## **APPLICATION TO DISCHARGE PRE-COMMENCEMENT CONDITIONS FOR REDEVELOPMENT AND CHANGE OF USE OF FORMER MILL SITE TO FORM 19 RESIDENTIAL UNITS**

**HINCHLIFFE MILL, WATER STREET, HOLMBRIDGE, HOLMFIRTH, HD9 2NX**

**LPA REF: 2026/90162**

Drawn	DRH
Date	April 2026
Scales	1:200 @ A1
Drawing No.	2559 - 0404 - P04

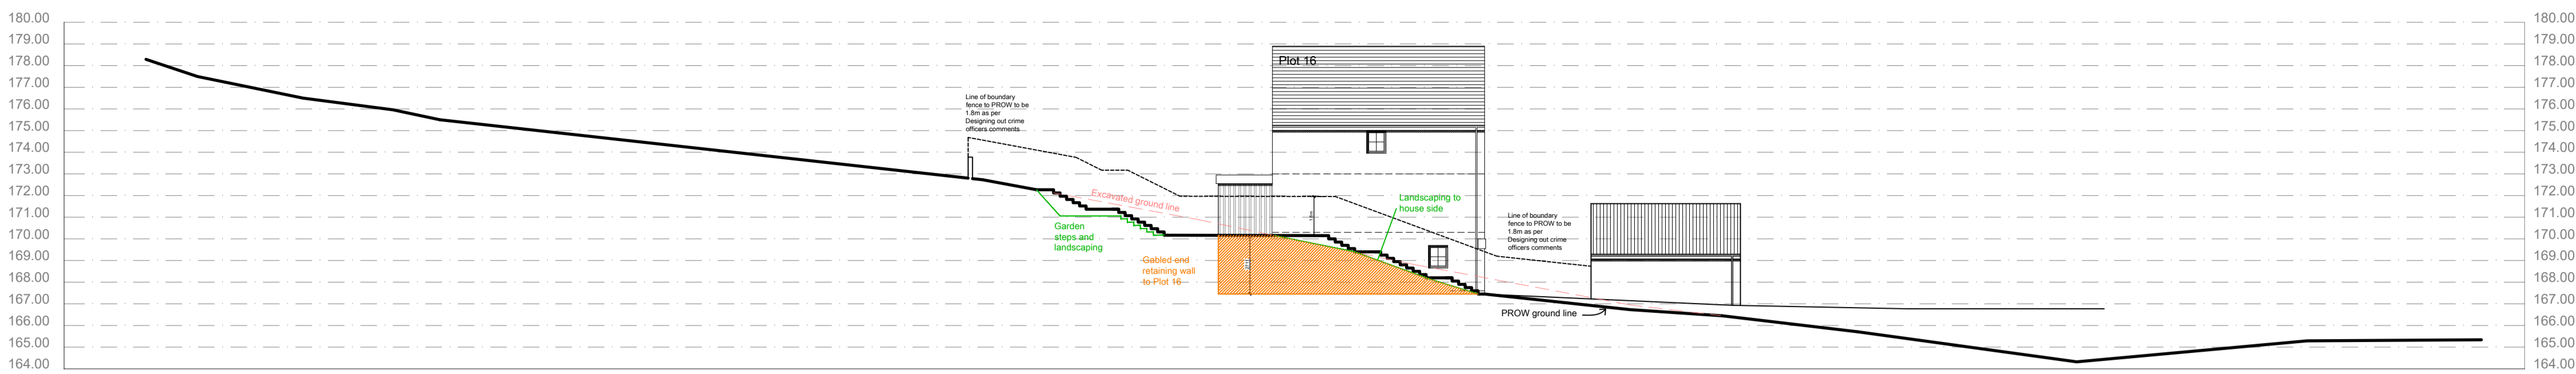
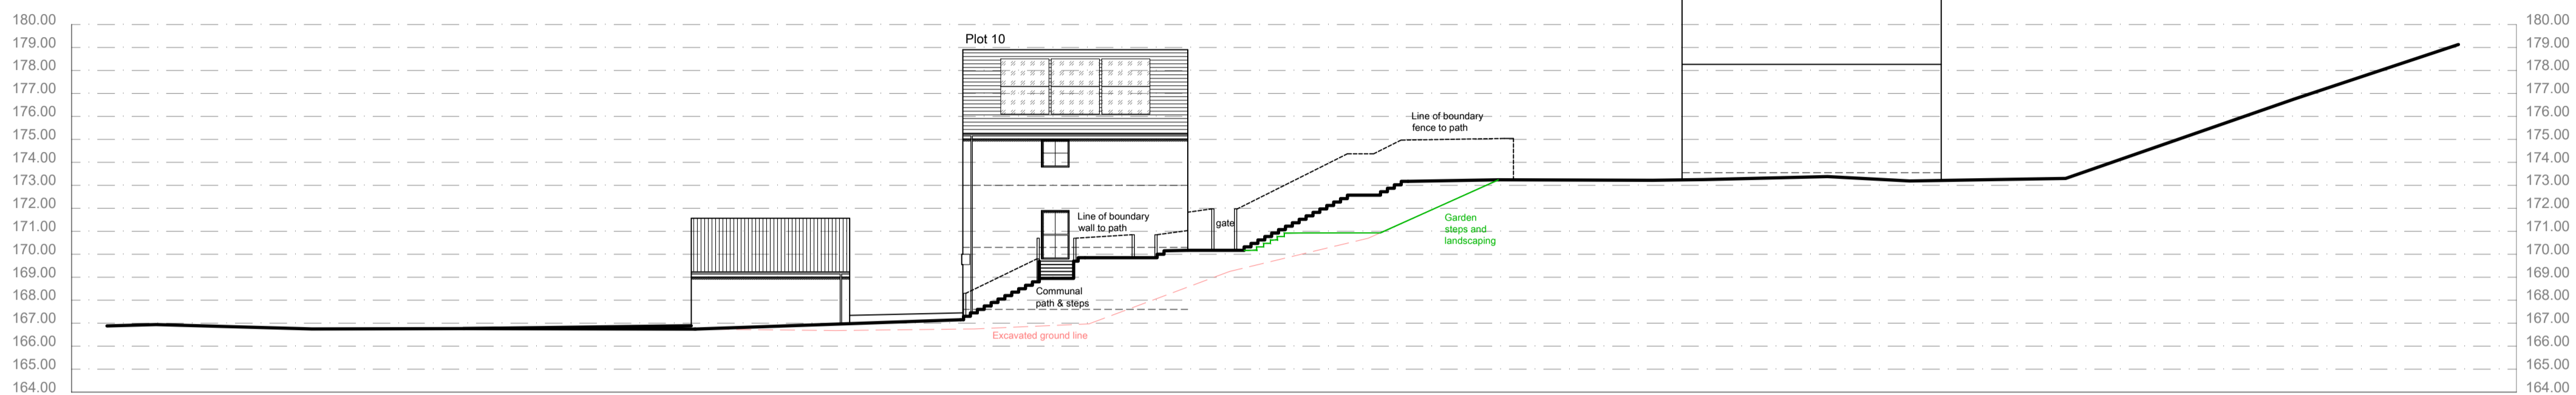
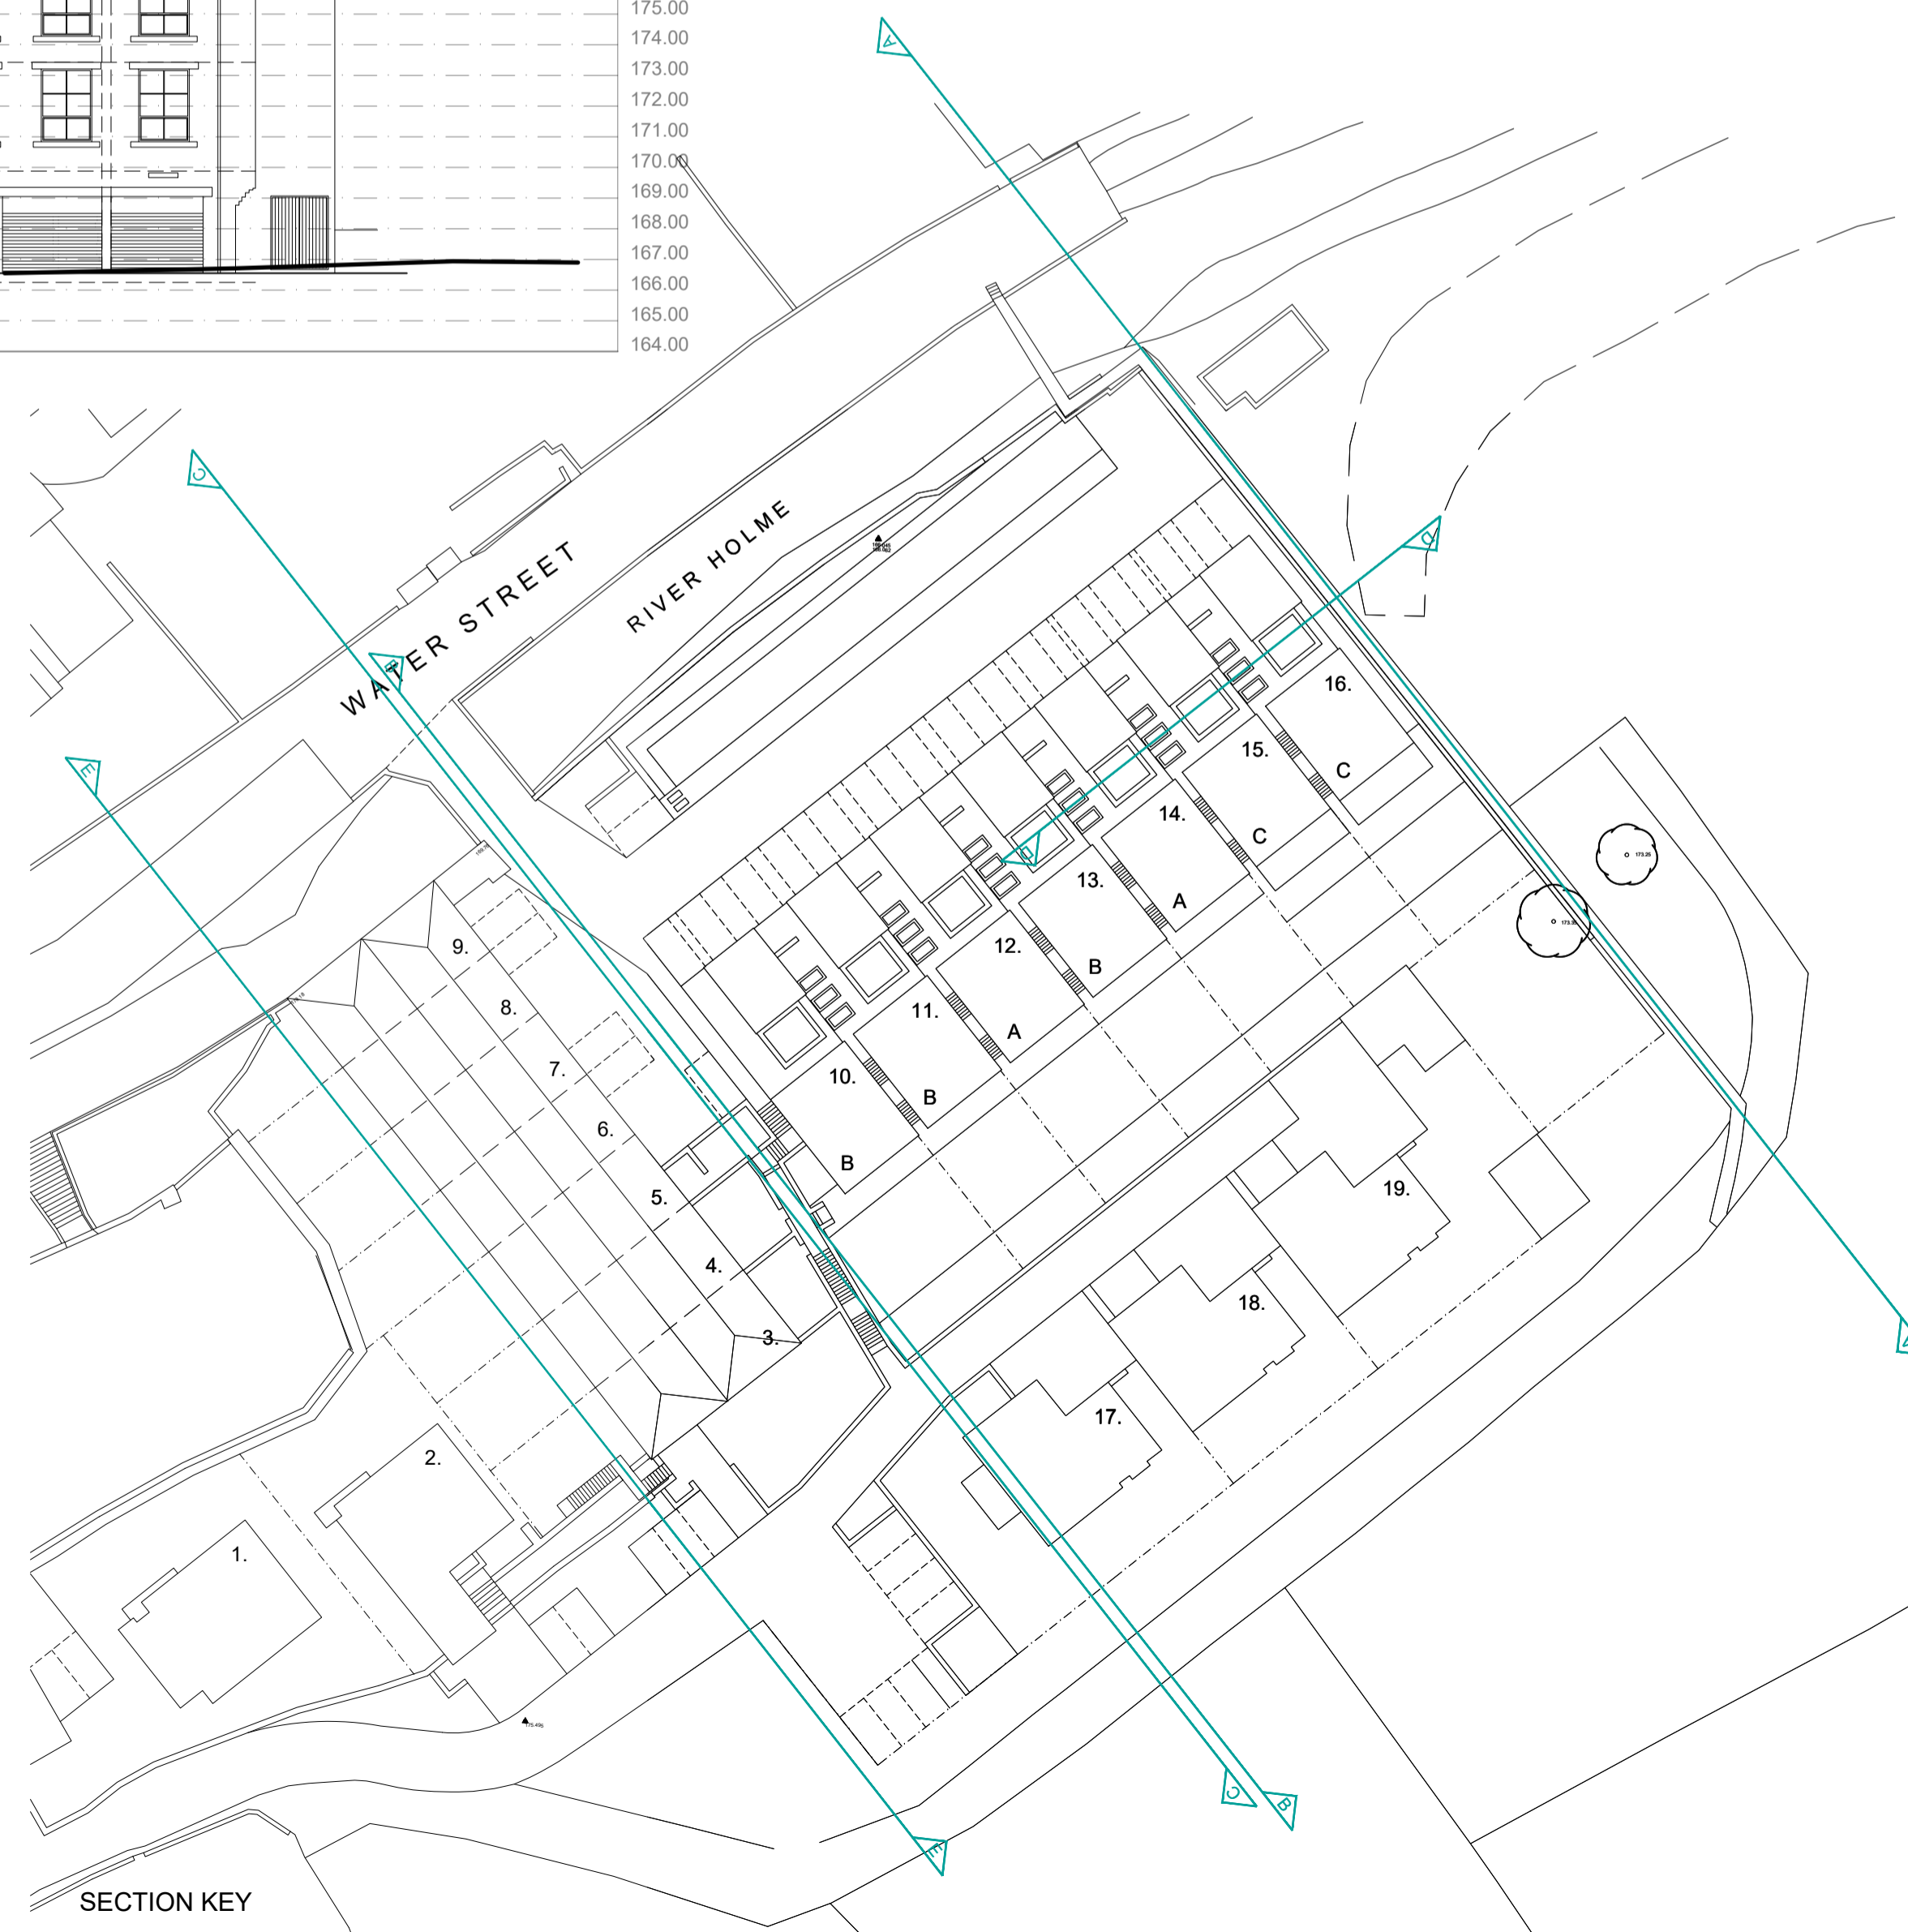
*“...the design of any new retaining walls adjacent to the proposed private roads will also be outside the remit of my consideration, however, I will require an external works plan confirming that there are no proposed retaining walls adjacent to the existing PRoW (HOL/95/10) before confirming that Condition 20 (highway retaining walls) can also be discharged. Please remind the applicant that I will need the advised drawing for reference to discharge this condition and not a confirmation via an e-mail. “The drawing requested by KC Highways Structures has not yet been submitted. Without such a drawing, officers cannot confirm formally whether any applicable retaining walls are proposed.”*

**Applicant’s Response:** In connection with recent work on the PROW diversion and re-instatement, it came to light that a retaining structure is likely to be required adjacent to the part of the new public footpath (see enclosed retaining wall plan by Heneghan Architecture). As such, the details below are submitted to address this (and which includes the requested plan showing the location of other retaining walls bounded by private roads / land).

1.2m High Estate Railings With Strainer Wire

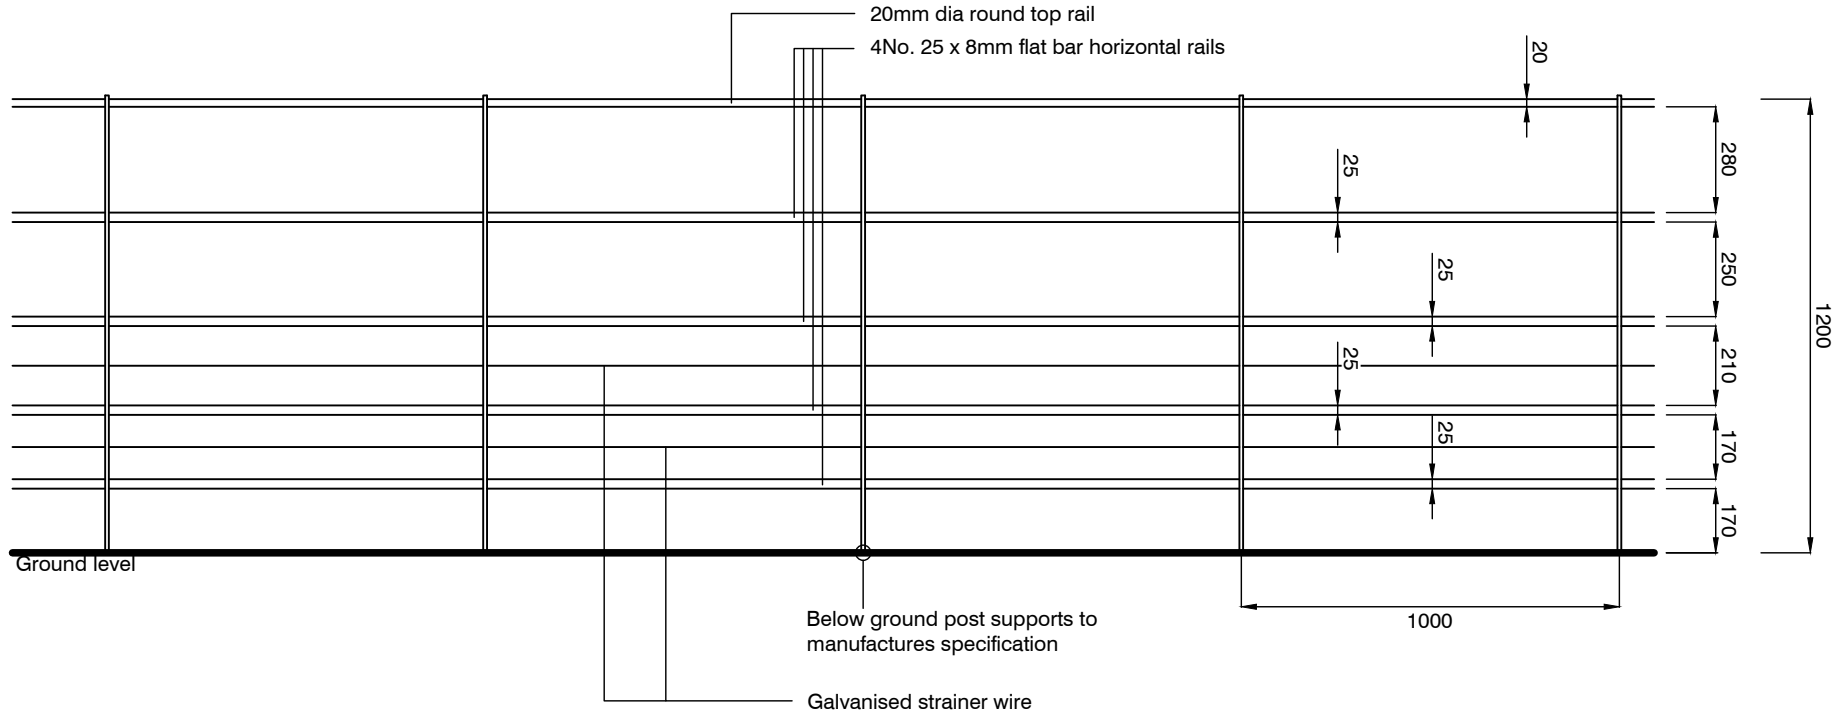
- 2) “The proposed timber fencing (both the 1.2m high post and rail fence and the 1.8m high vertical timber hit and miss fencing) and the extent of its proposed use are of significant concern. At a site that, historically, never would have had such boundary treatments, the proposed timber fencing would appear incongruous. Different boundary treatments, more

*(Further comments received in email 14/5/26) “Re: fencing, no timber should be proposed. As per the delegated report for 2025/93383, the previously proposed dry stone walls (subject to their height being confirmed), metal railings (painted black) and native hedging would be appropriate boundary treatments for this site.”*

**Applicant’s Response:** All timber boundary treatments has now been removed from the plans and replaced with either hedging, masonry stone walls, or metal fencing.

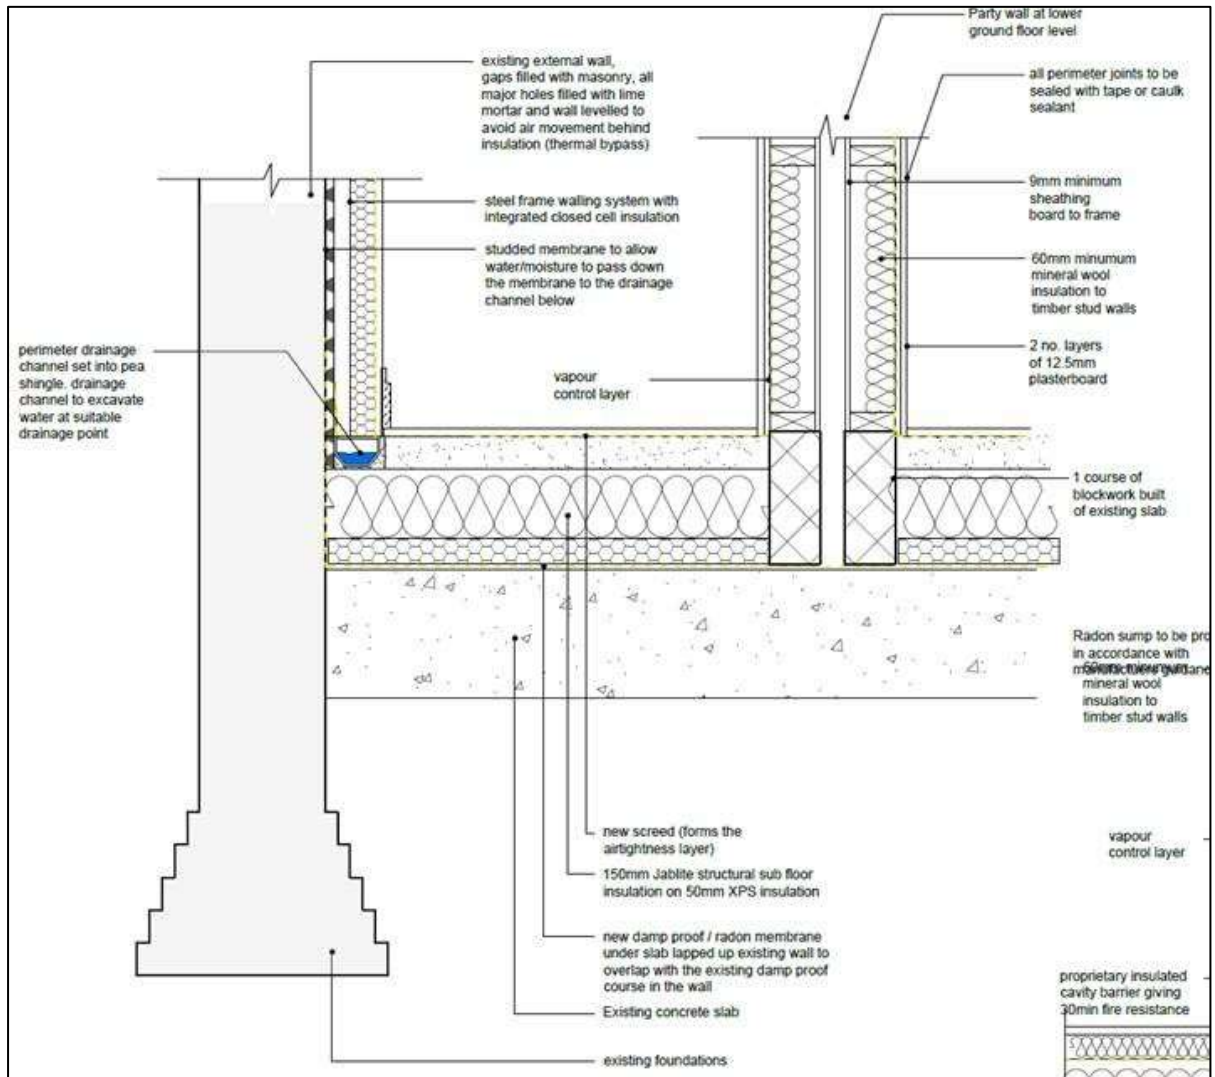
Although this condition was previously approved, the applicant now seeks to amend the submission details in accordance with the enclosed letter from On Site Archaeology dated 24<sup>th</sup> April. In summary, since submission of the previously approved Written Scheme of Investigation, the design of the development has been modified so that no groundworks are required below the existing concrete floor slab within the northern section of the mill. This means that any archaeological remains that may be present will be undisturbed by the development and will remain preserved in-situ.

Flood Plan and Hand Over Information

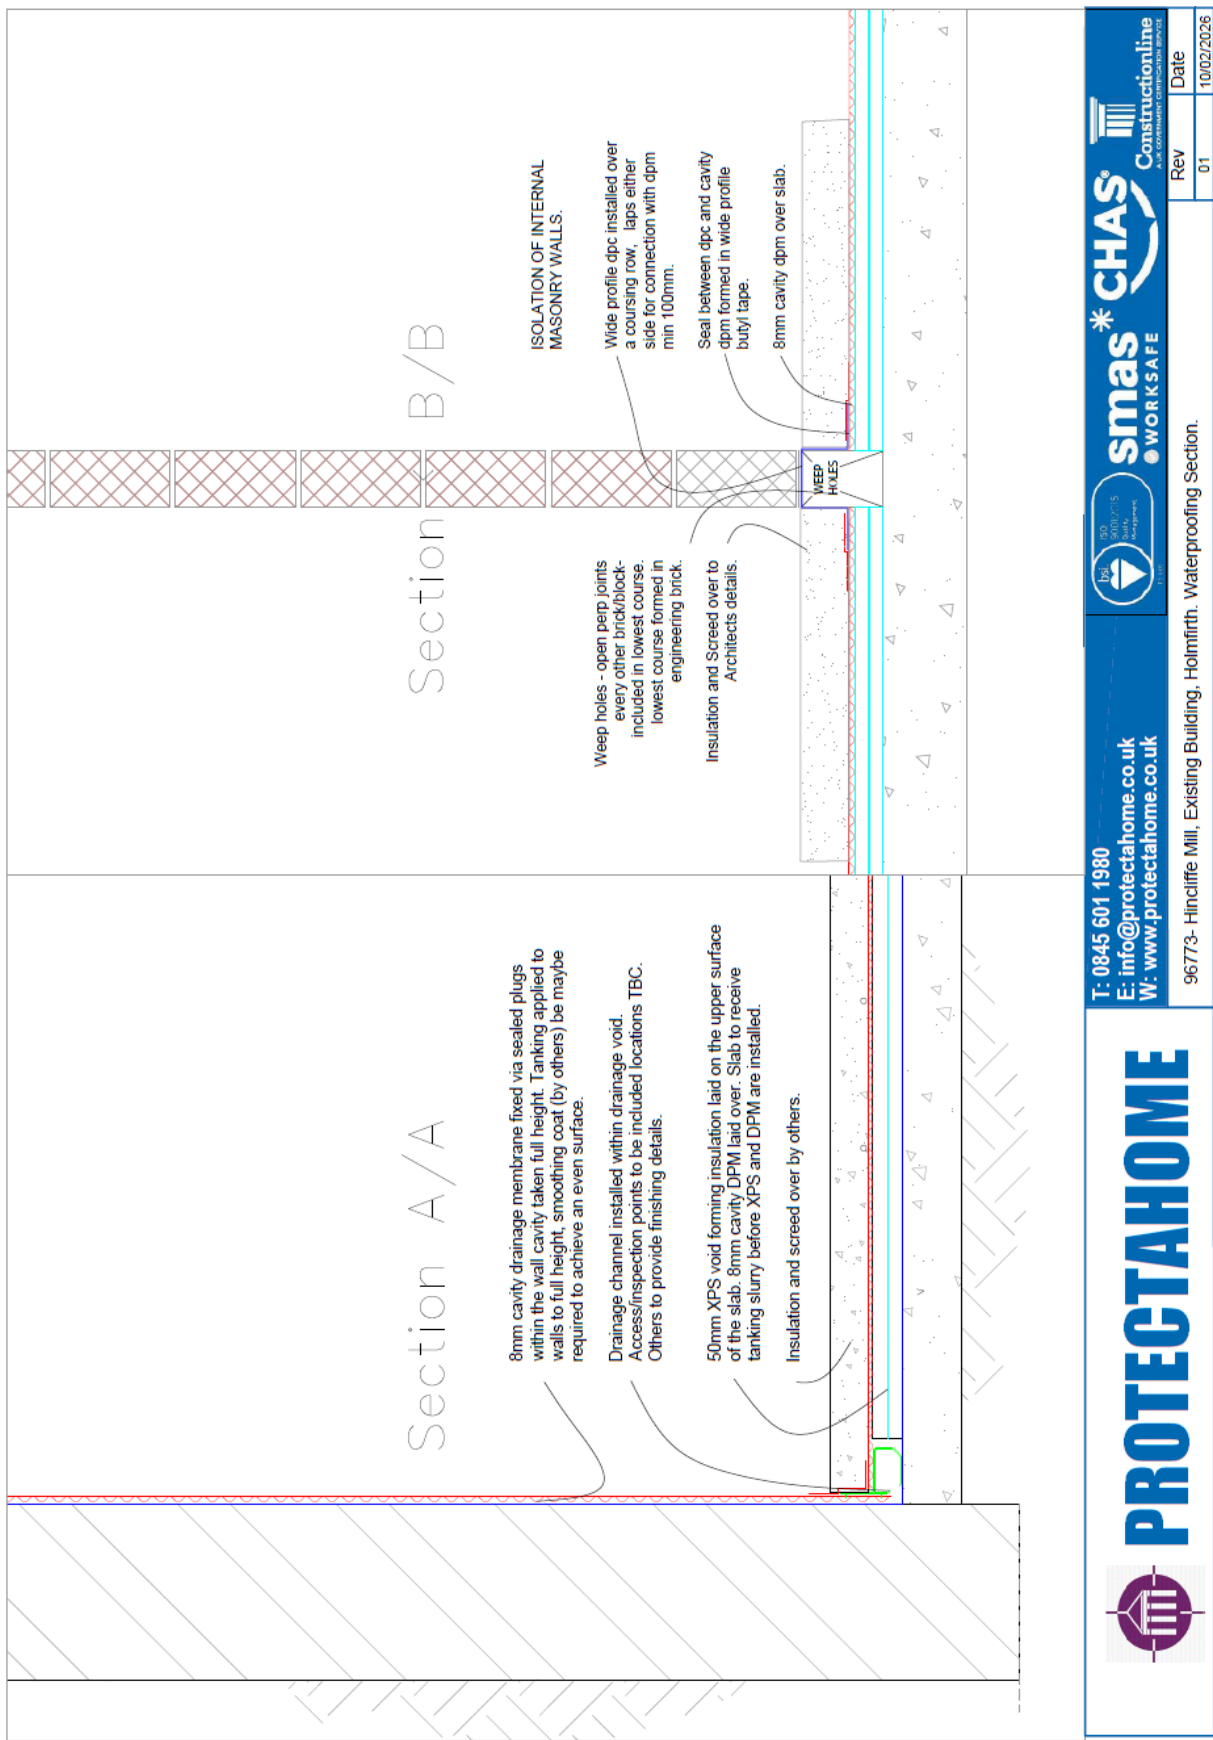
“At page 7 of the submitted Drainage Conditions document, under a “Flood Resilience Measures” heading, the author states “Consideration should be given to flood proofing non habitable ground floor level to units 5, 6, 7, 8 and 9 to reduce the residual damages if a critical event was to occur”. On the following page the author sets out a list of recommended flood proofing measures “which can be incorporated within the design of buildings”.

The details submitted pursuant to condition 9d are brief, they only refer to units 5, 6, 7, 8 and 9 (whereas condition 9d also refers to units 3 and 4), and the ambiguous wording (“Consideration should be given”, “recommendations” and “can be incorporated”) means it is unclear whether any flood resilience measures are to be implemented.”

**Applicant's Response:** The enclosed Flood Proofing Scheme should now address all these outstanding points.
